Application H12-1056-20
Location COCK AND MAGPIE COTTAGE 18 GEDNEY ROAD LONG SUTTON
PE12 9JN
Proposal Proposed extension, alterations and detached garage

Name Ian Marshman, Historic Environment Officer
Address Lincolnshire County Council Lancaster House 36 Orchard Street LN1 1XX

Date Submitted 02-02-21
For/Against Comments

PLAN AS PROPOSED

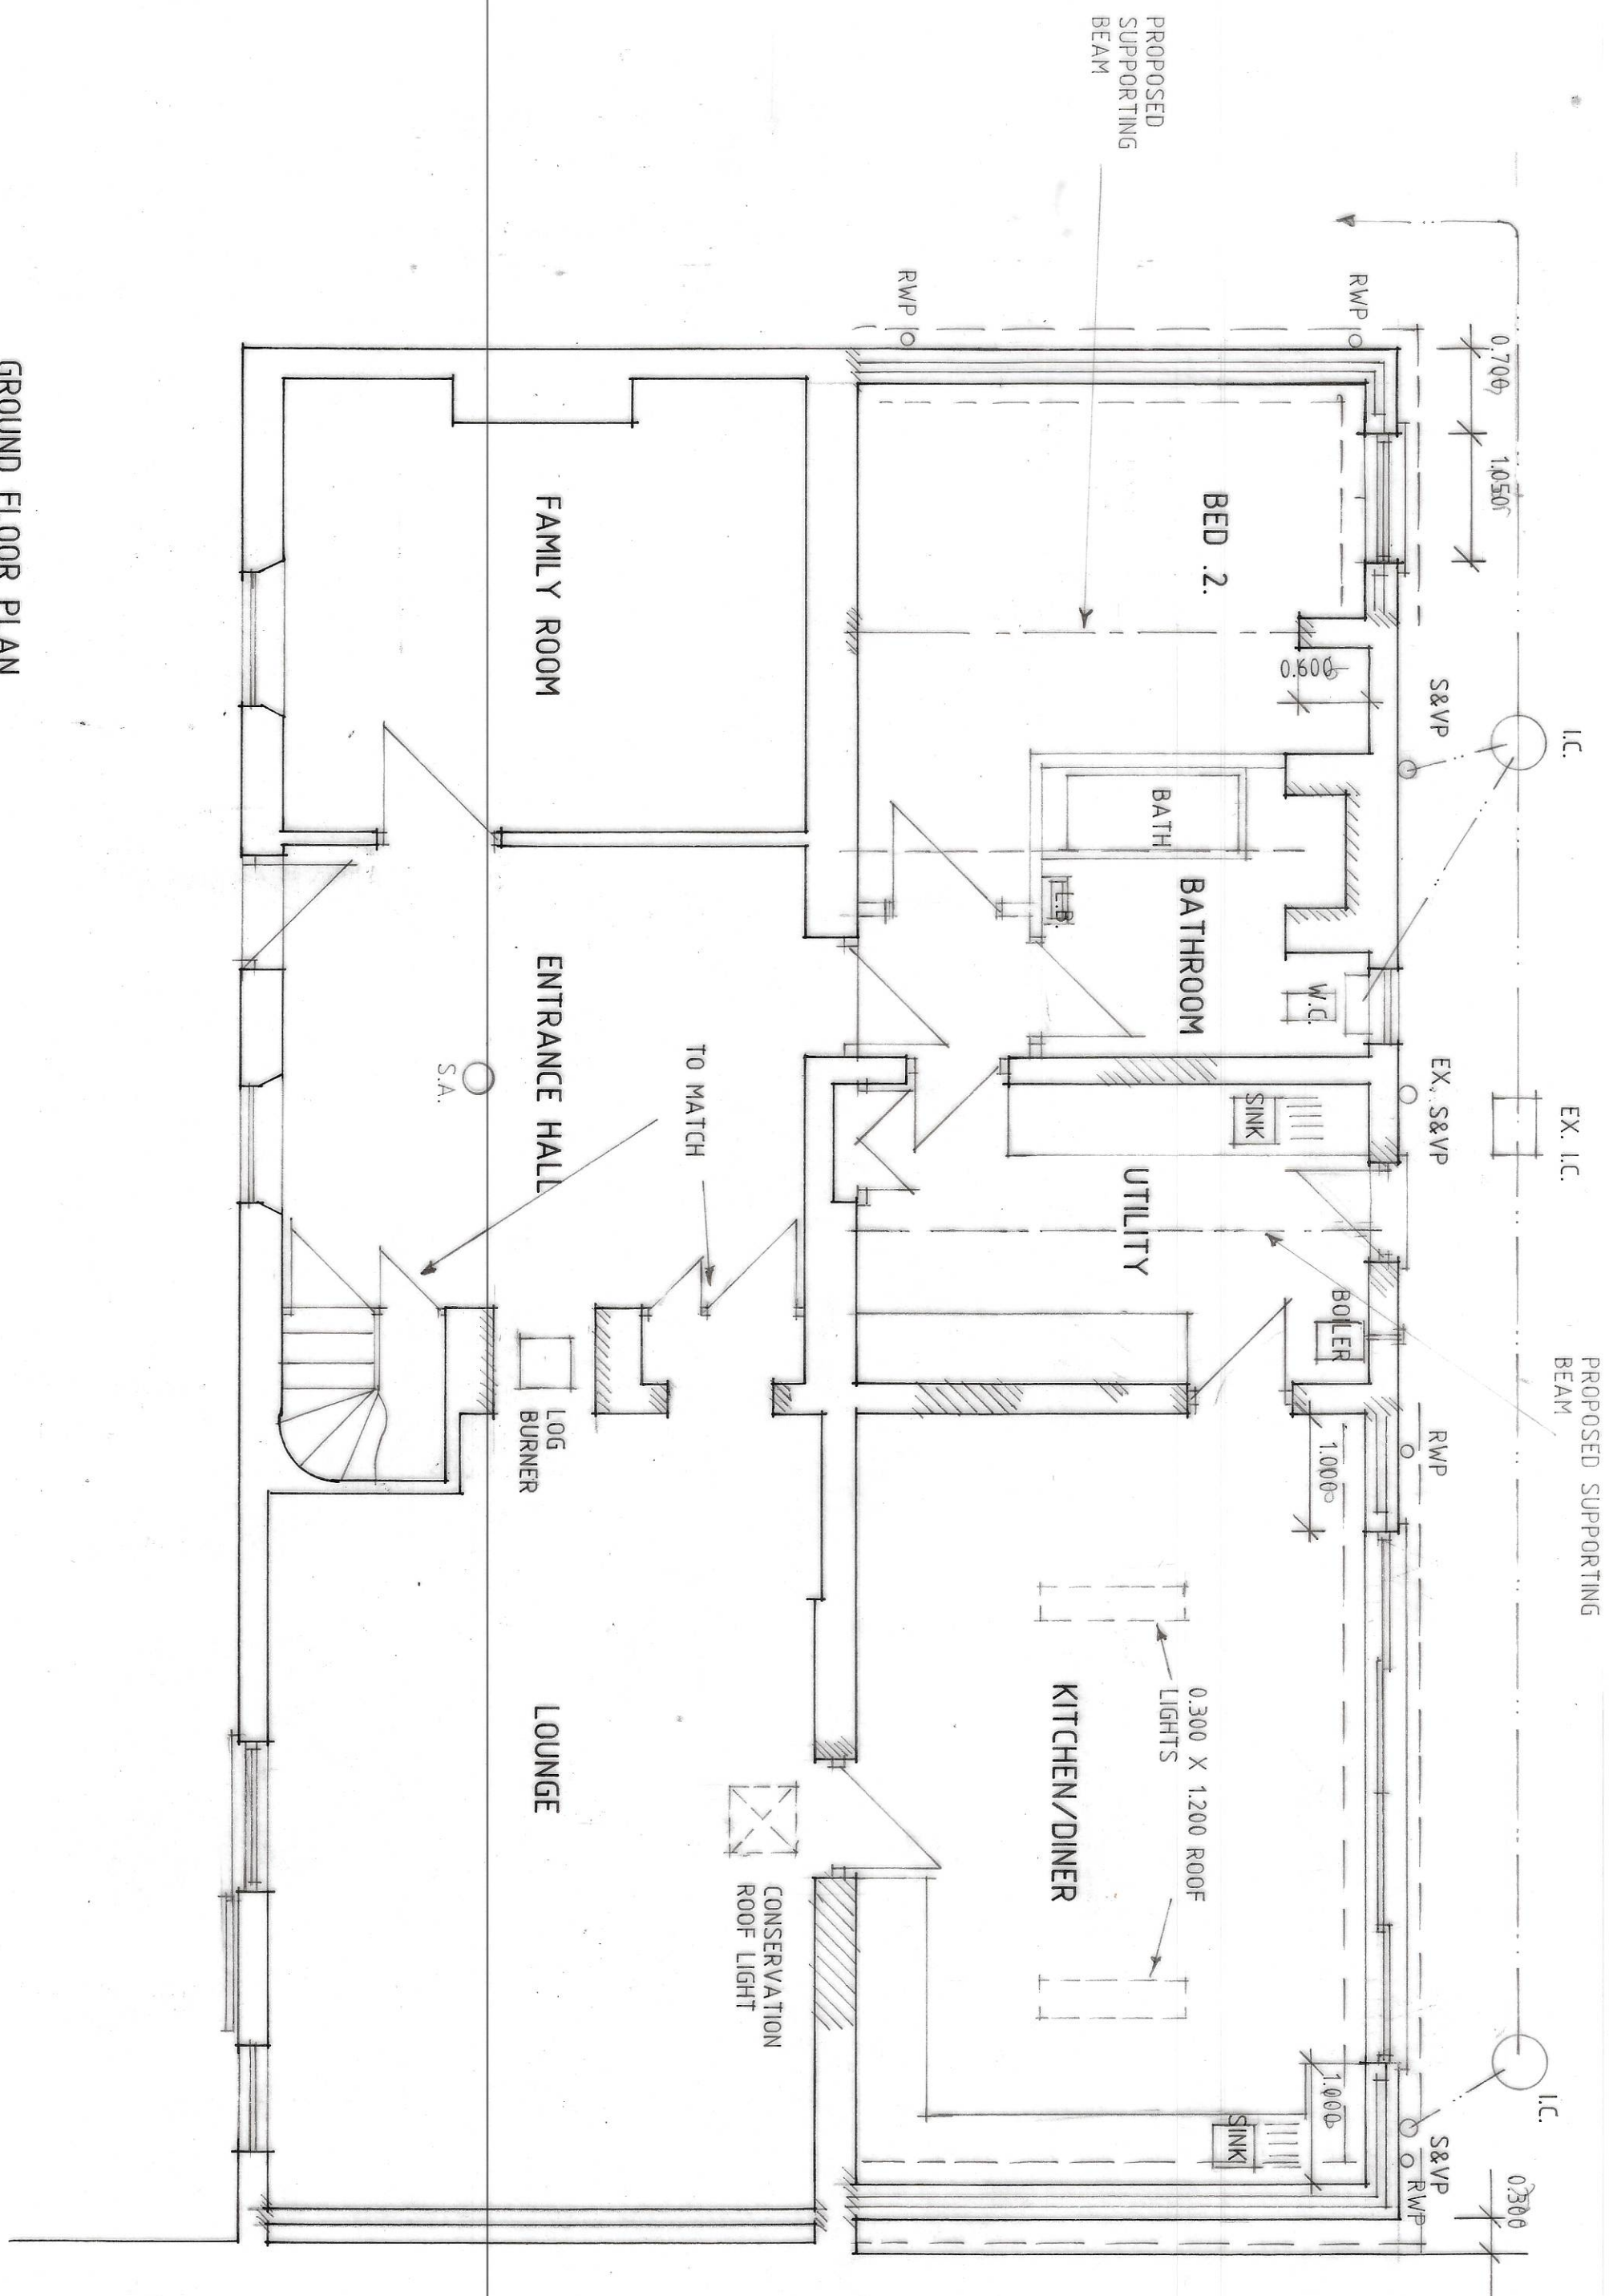
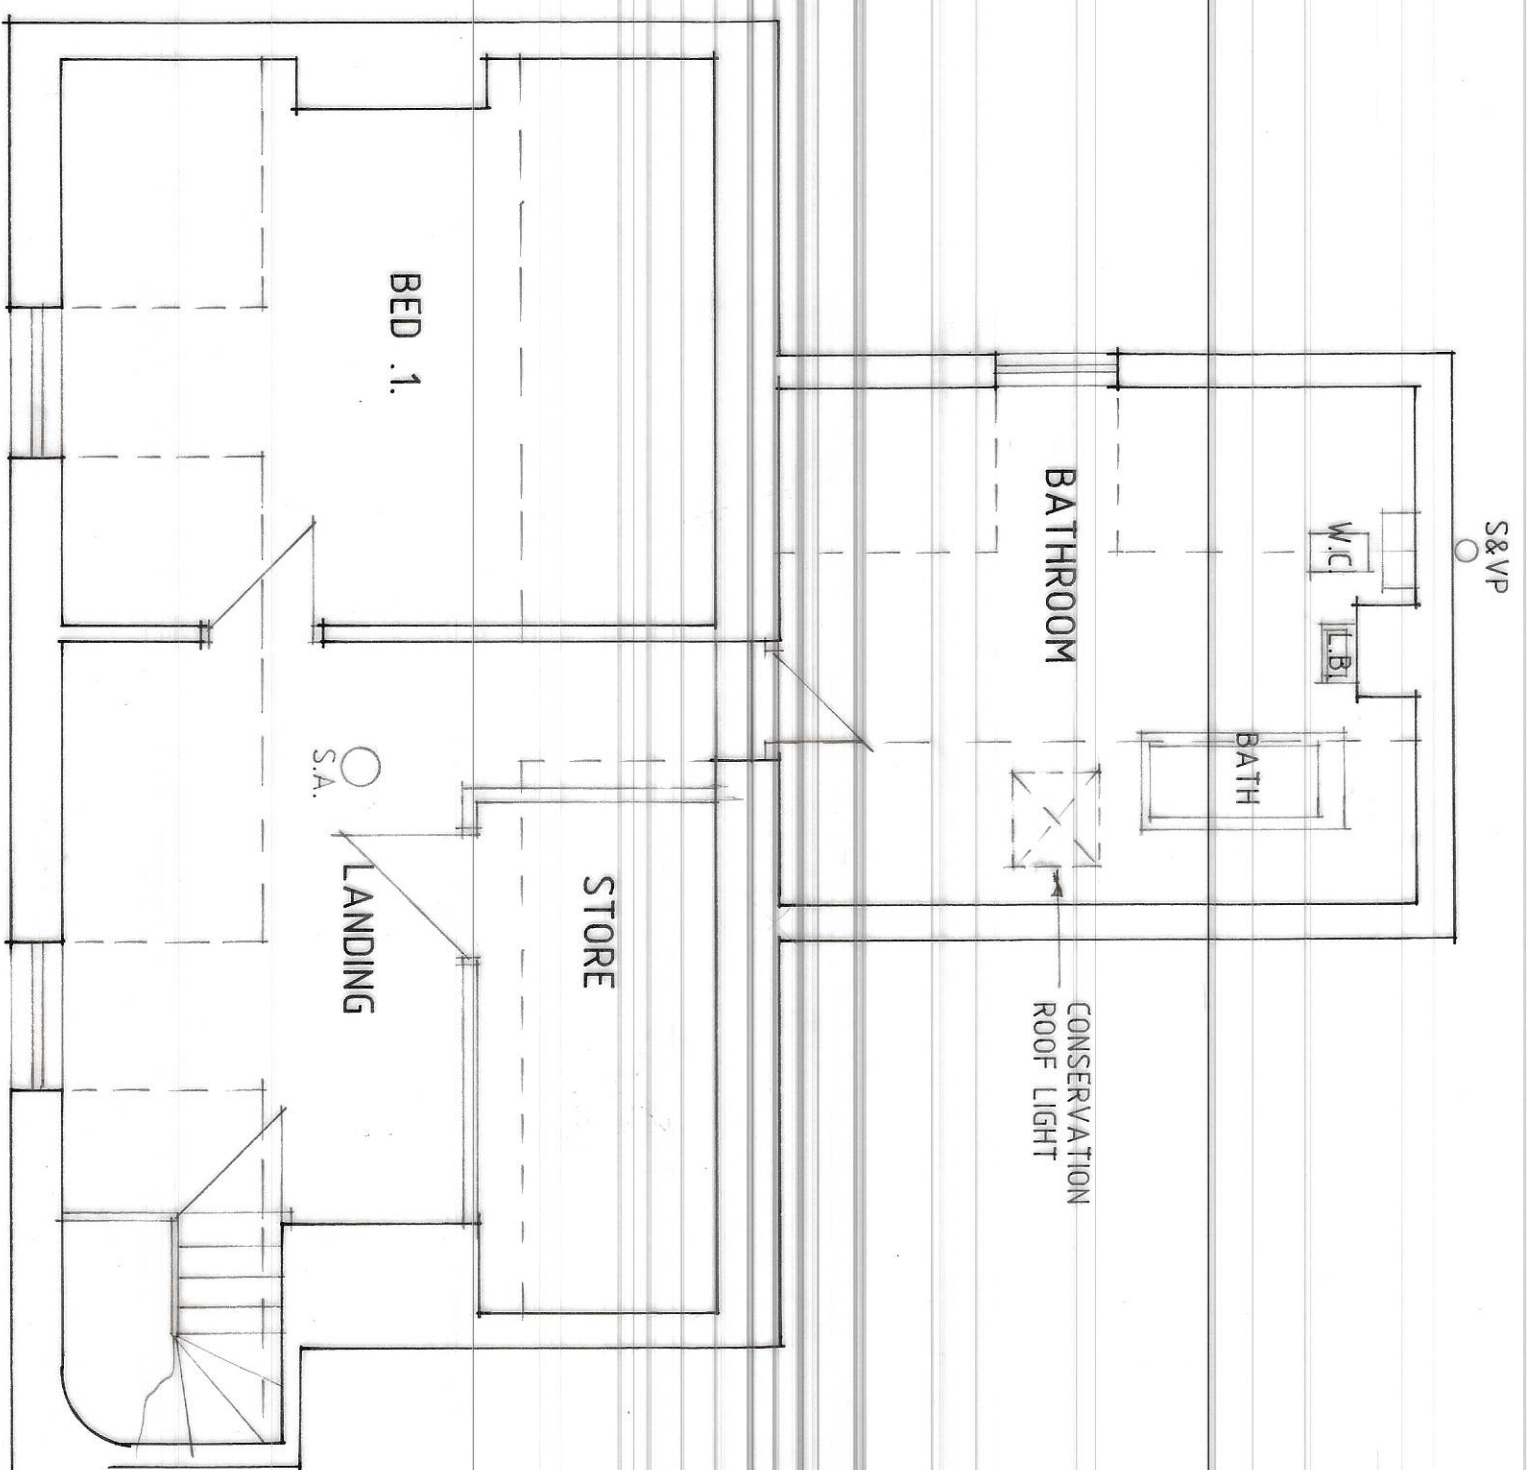
The proposed development involves alterations to the Grade II Listed former Cock & Magpie public house dating from the eighteenth century. The proposals would see a number of changes to the historic fabric particularly within the historic attached outbuilding to be converted, as well as the loss of some features of interest including a pilastered fitted cupboard to create a new doorway in what would have been original parlour or public bar.

If the local planning authority is minded to grant consent, it is recommended that the developer should be required to undertake a programme of historic building recording prior to any alteration or conversion taking place. This should be secured using an appropriate condition requiring the record be submitted and approved by the local planning authority prior to development commencing.
